CITY OF ALBUQUERQUE

October 13, 2020

**Re: Aspire Traffic Impact Study (Anderson Heights)
between Amole Mesa Ave./Colobel Ave and 98th/118th NW
Traffic Impact Study, Draft
HT#N08D006F, Dated September 2020**

After review of the Aspire Traffic Impact Study (Anderson Heights) dated September 2020 the City's Transportation Development has the following comments and corrections.

Count Name: NM285.02 - Anderson Heights TIS
Site Code: 98th & Amole Mesa
Start Date: 08/05/2020
Page No: 1

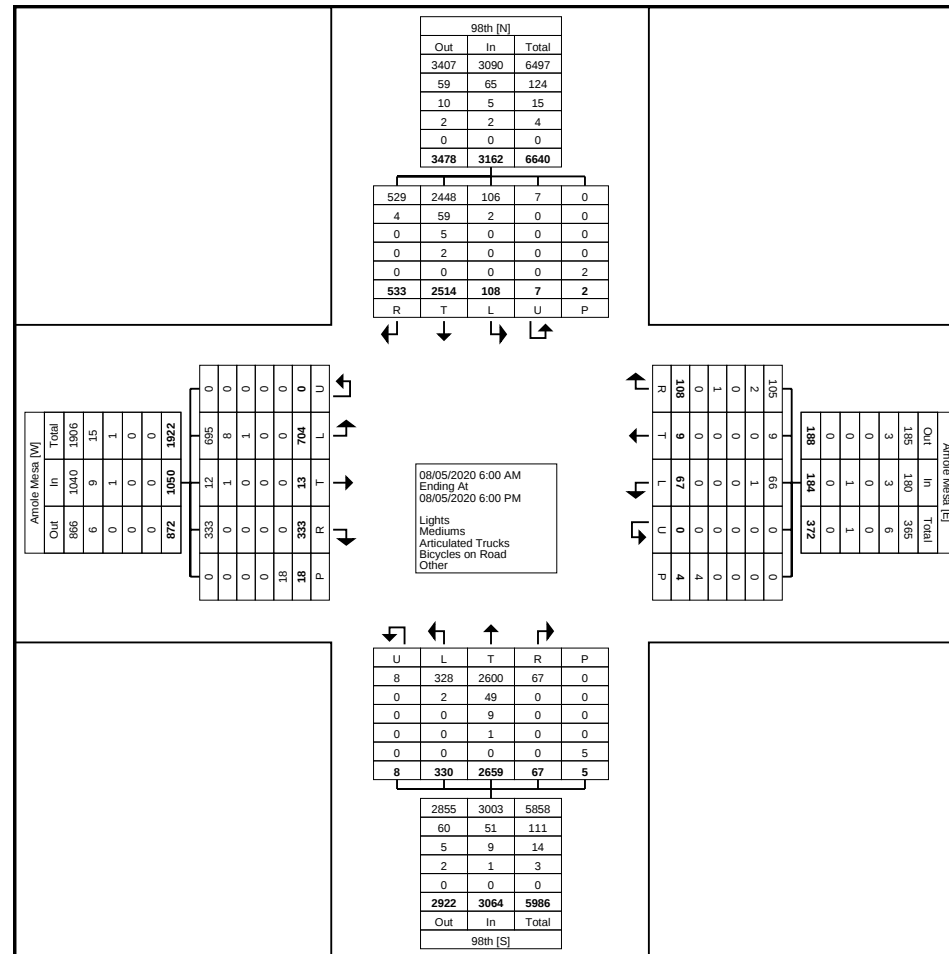
7. Describe the recommended mitigation for the Condershire Dr. and Dennis Chavez Blvd intersection.
8. The proposed traffic signal at the 98th St. and Amole Mesa Ave. intersection does not meet warrants in the current year or with future estimated 2027 traffic. Other intersection control should be considered if operations of this intersection are unacceptable.
